**AB/7/21/L**

*Vyne Cottage 33 Mount Pleasant Arundel BN18 9BD*

*Listed building consent for the replacement of 12 No. windows & 1 No door*

Drawing Title:
Proposed Windows and Details

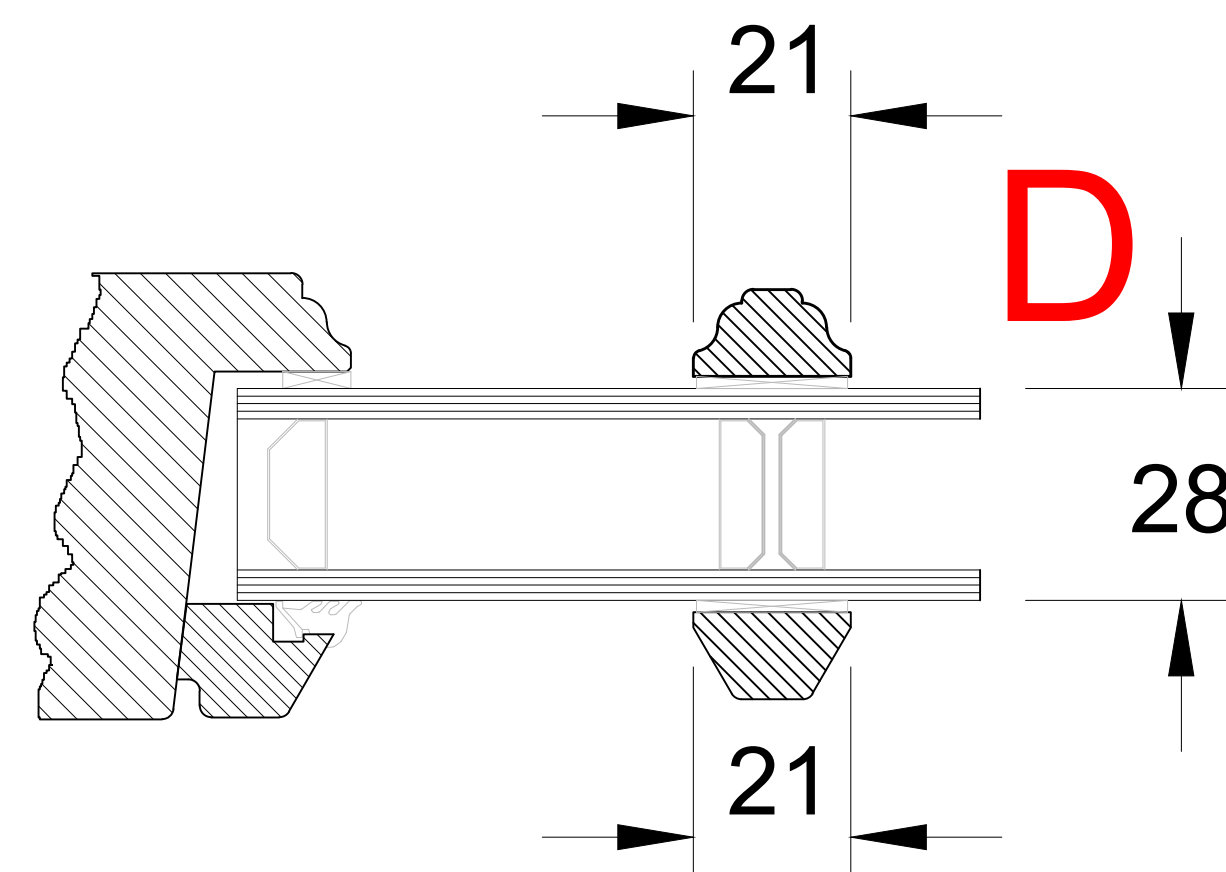
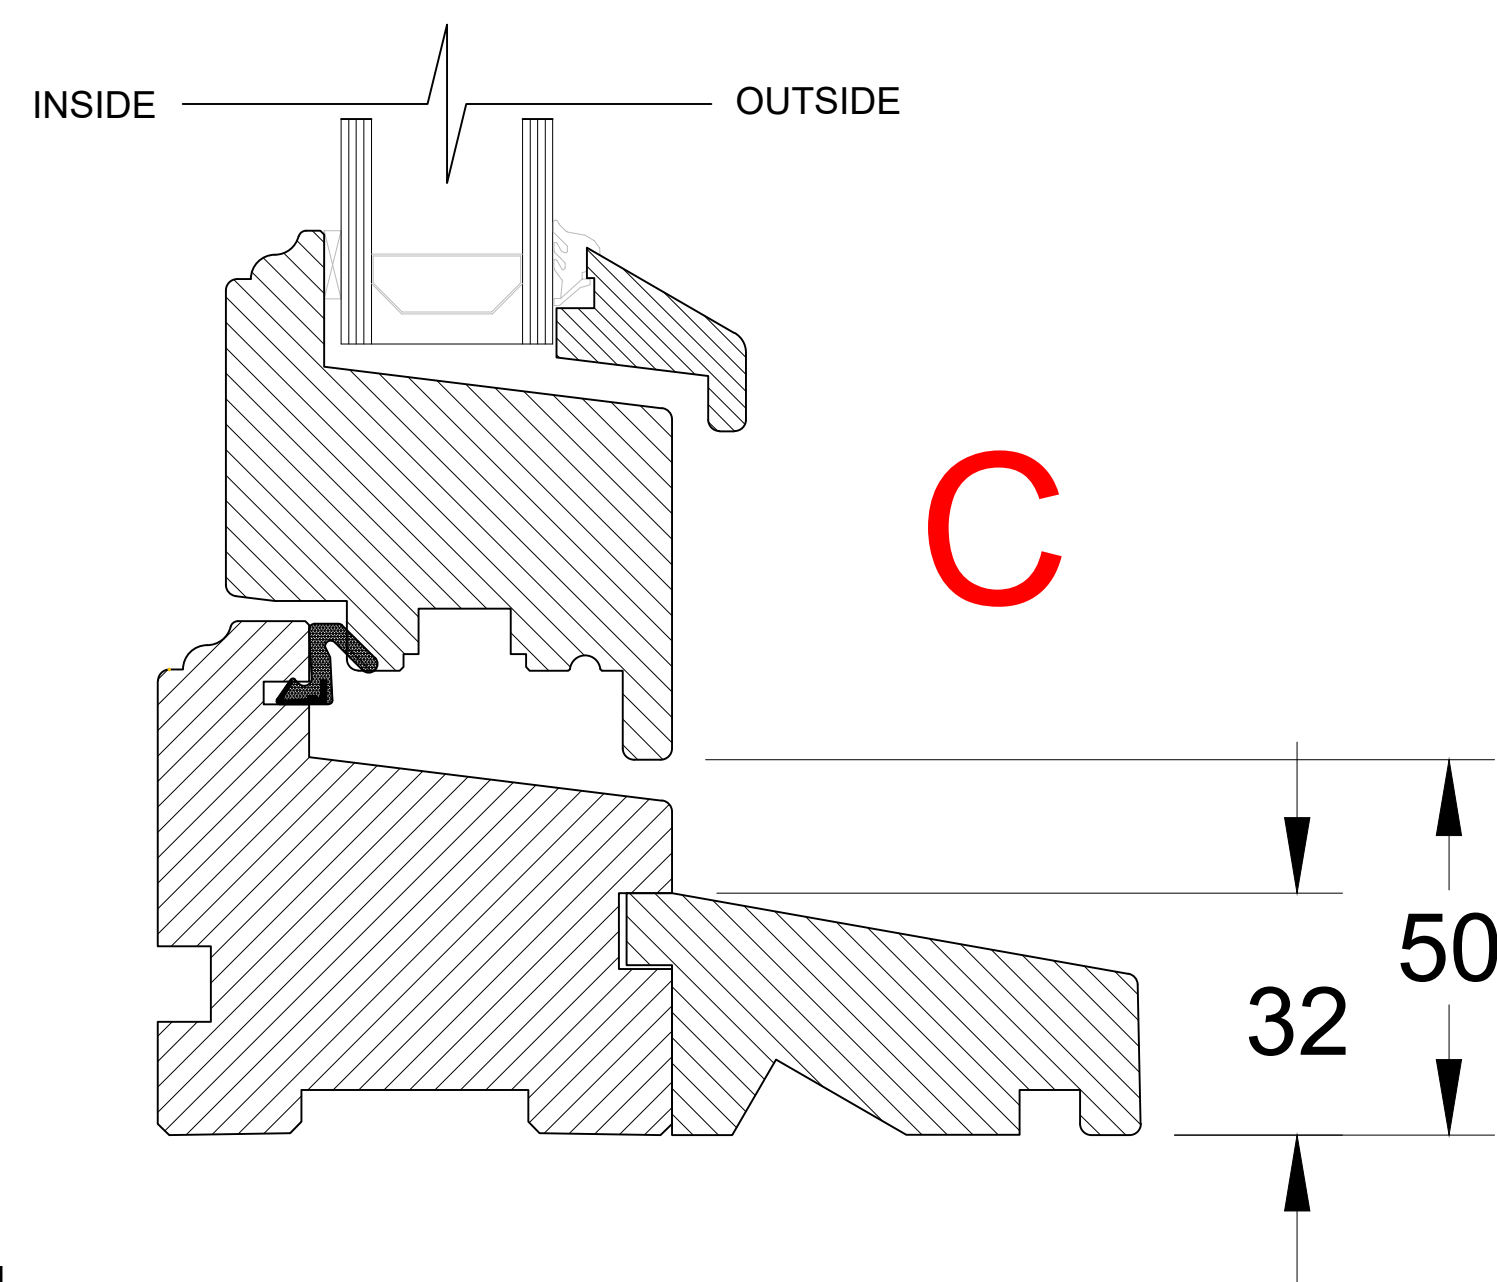
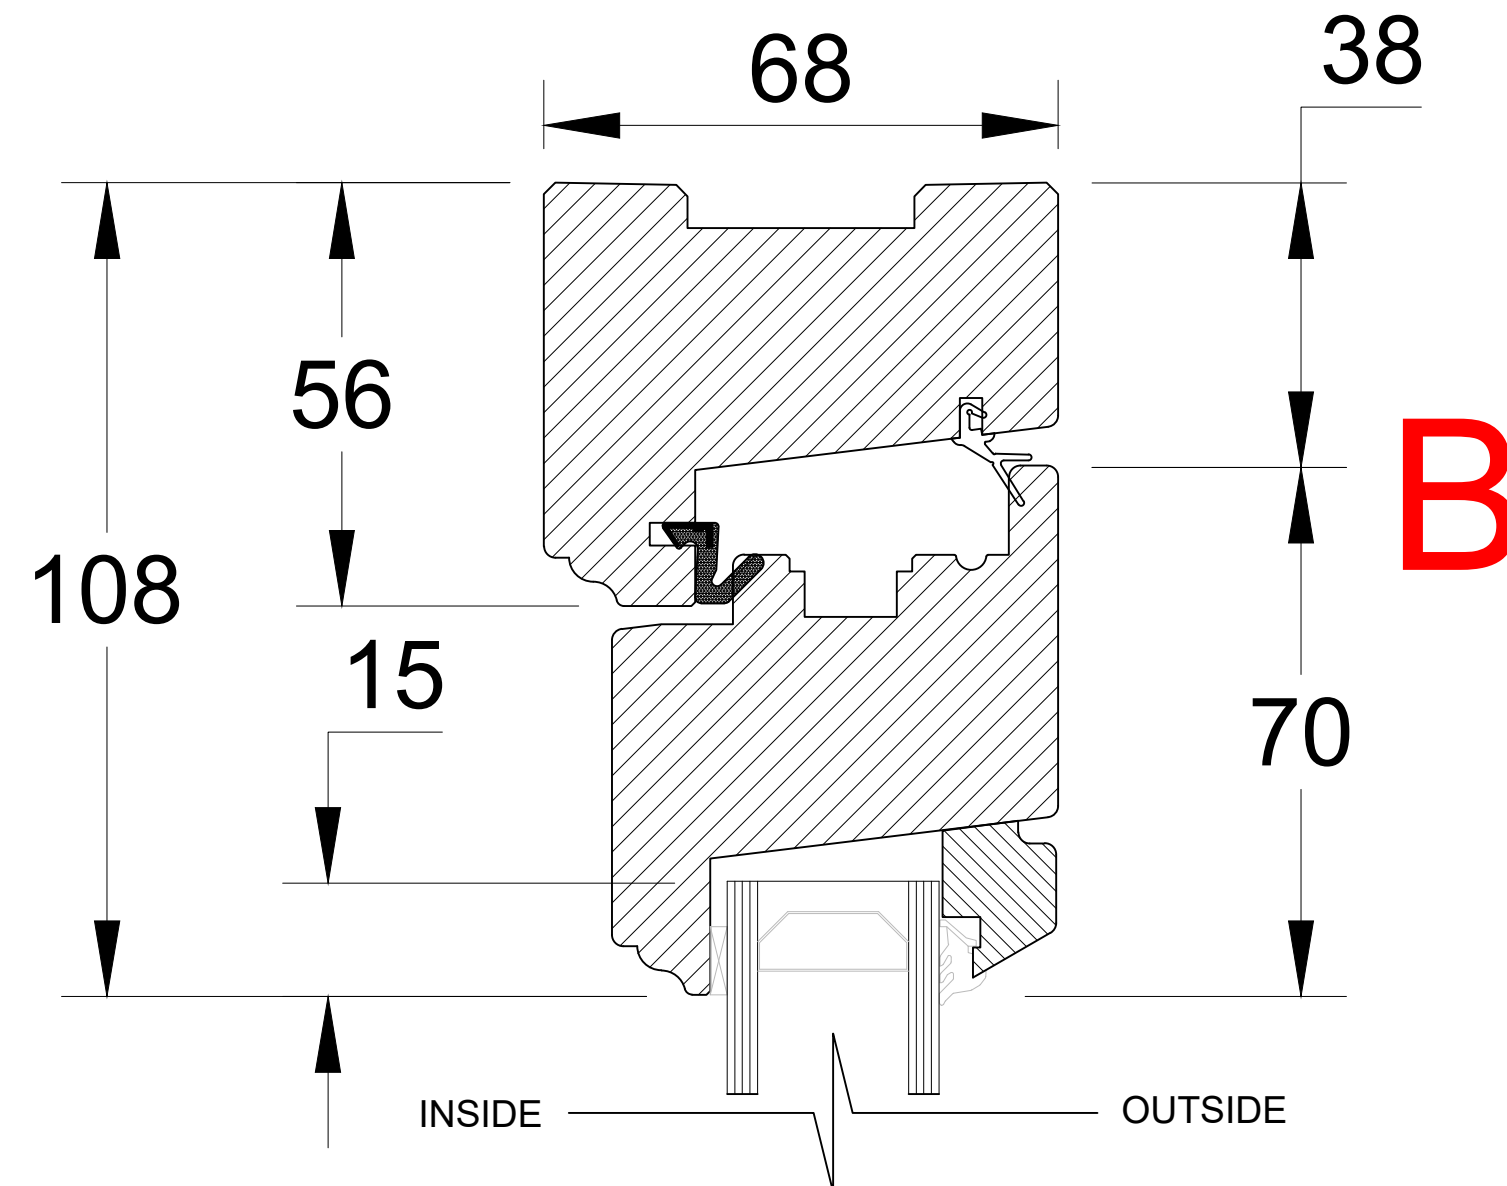
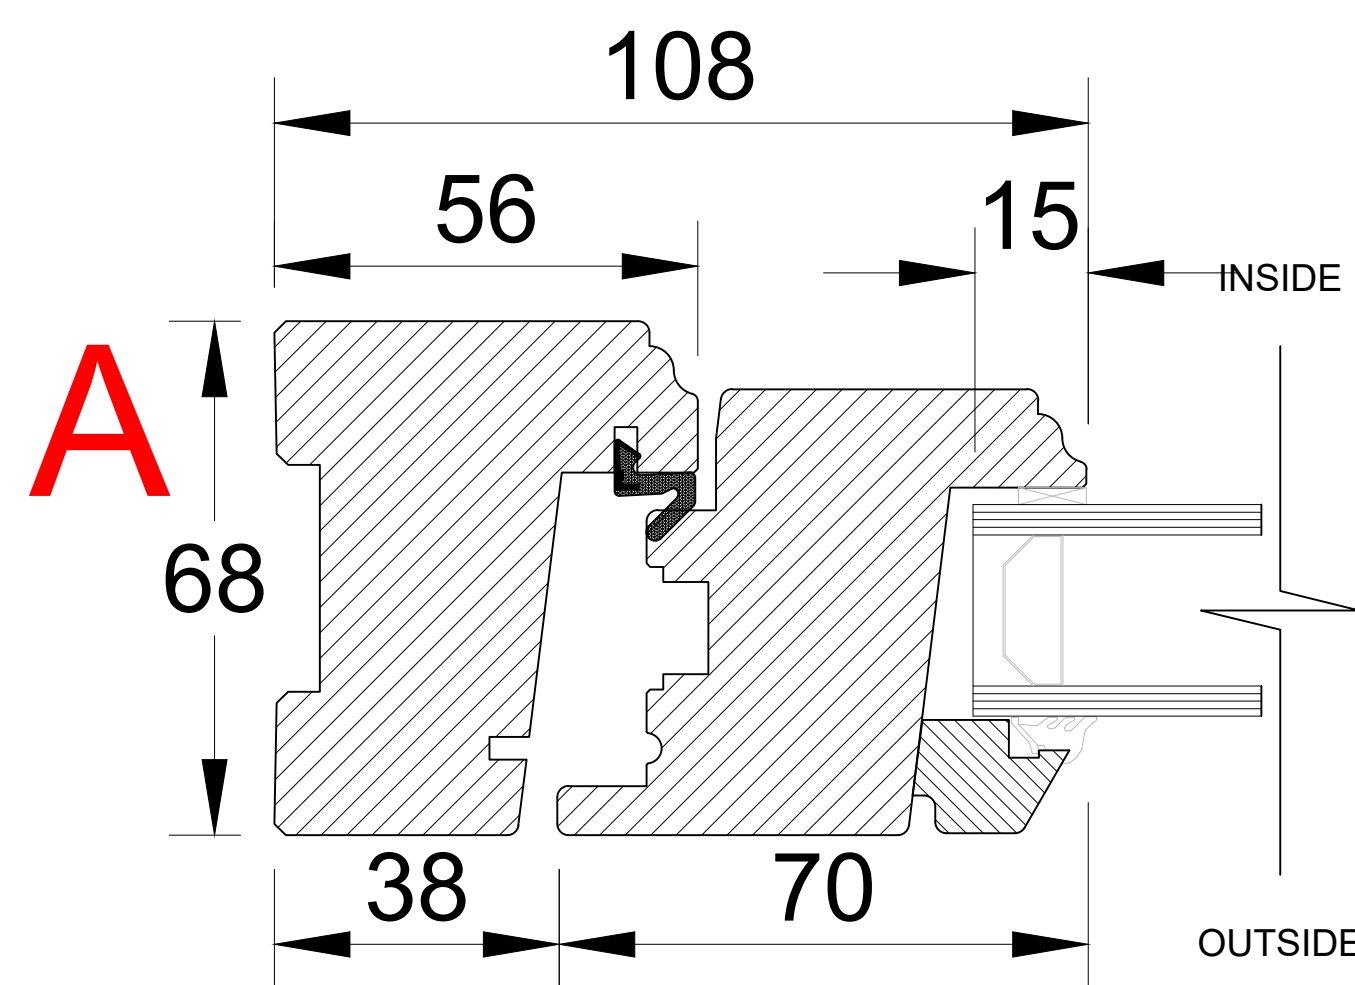
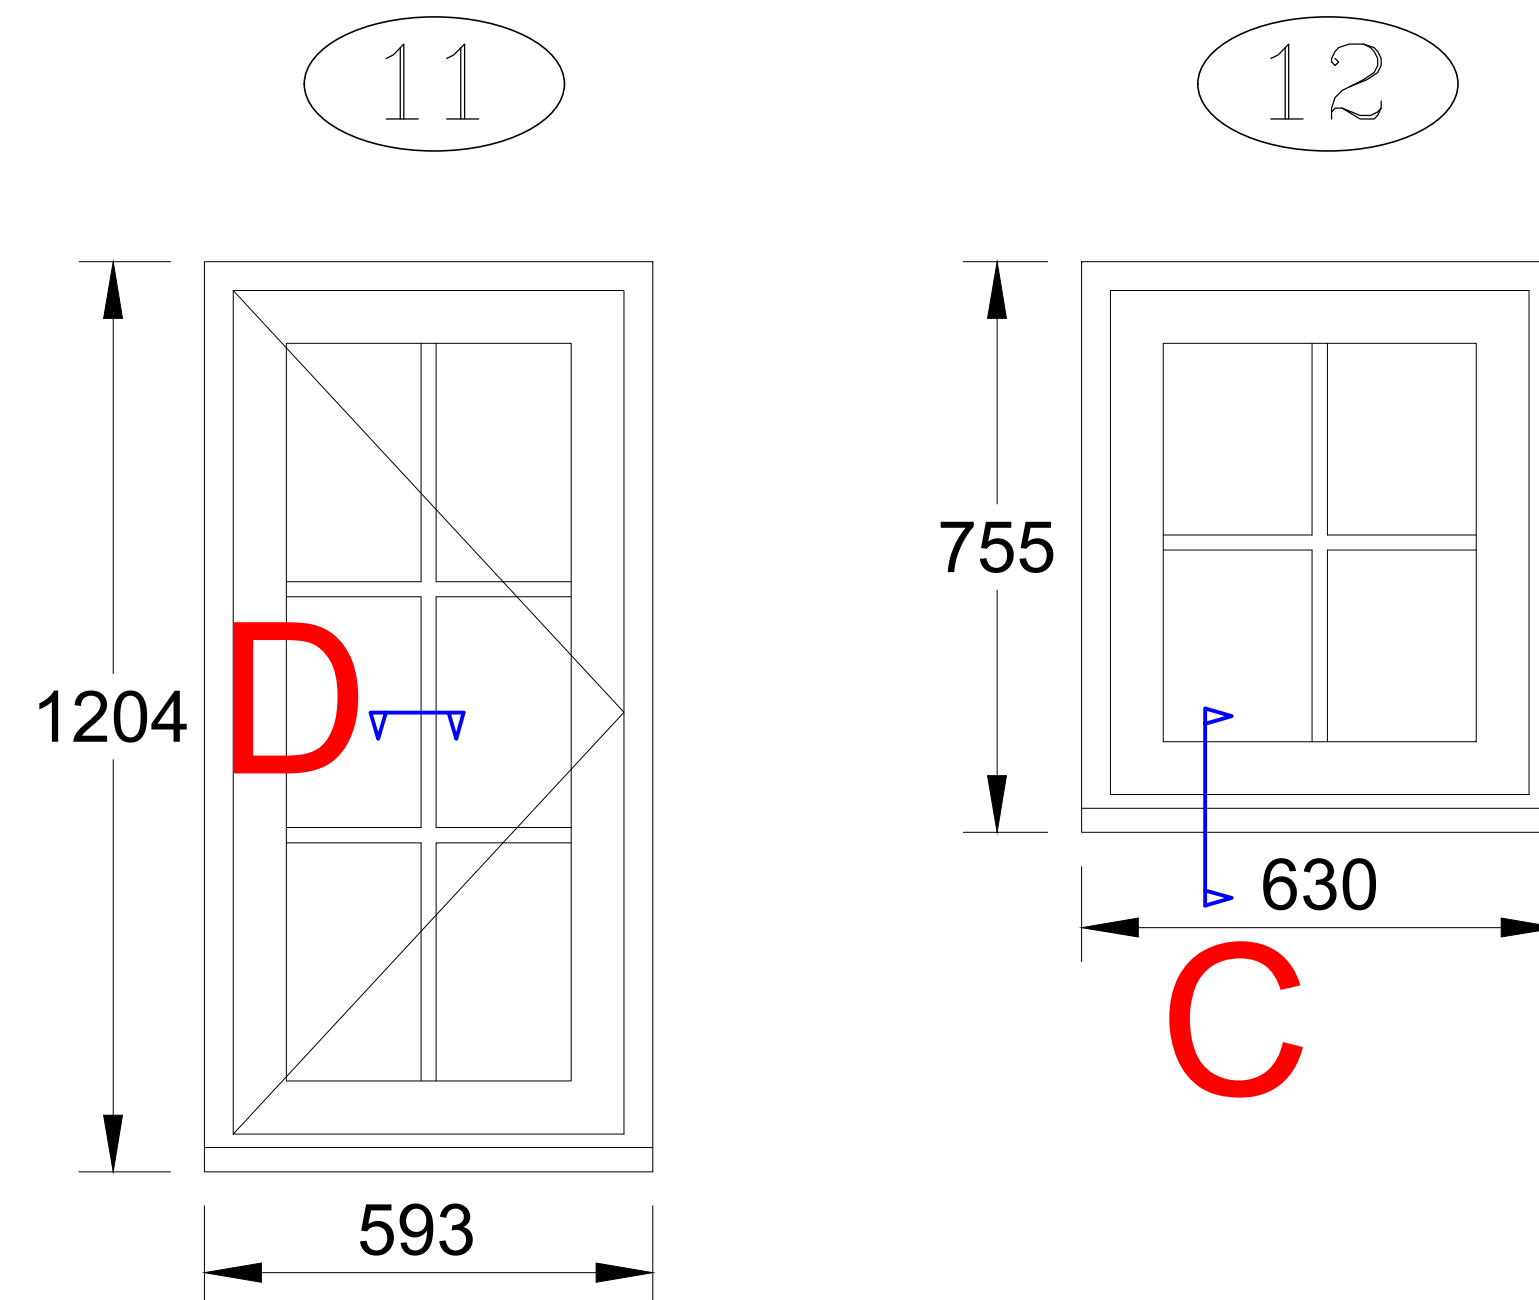
The proposal is for timber windows which incorporate 28mm double glazed units, along with the use of thermal spacers will not only increase the perception of modern, standard windows, but also affect the design of the windows themselves. Traditionally, where windows have glazing bars, these form part of the structure of the window. False glazing bars applied to the surface of the window are therefore historically incorrect, and aesthetically unconvincing. The use of applied glazing bars is therefore not appropriate for a listed building and should be integral to the windows. This type of double glazed unit and window design is therefore not appropriate for a listed building and is considered to cause harm.

An alternate approach would be to revise the design of the windows so that the much slimmer glazed units are used alongside windows/doors which include fully functioning glazing bars. However, at present of the proposal is not acceptable and is considered to be harmful.
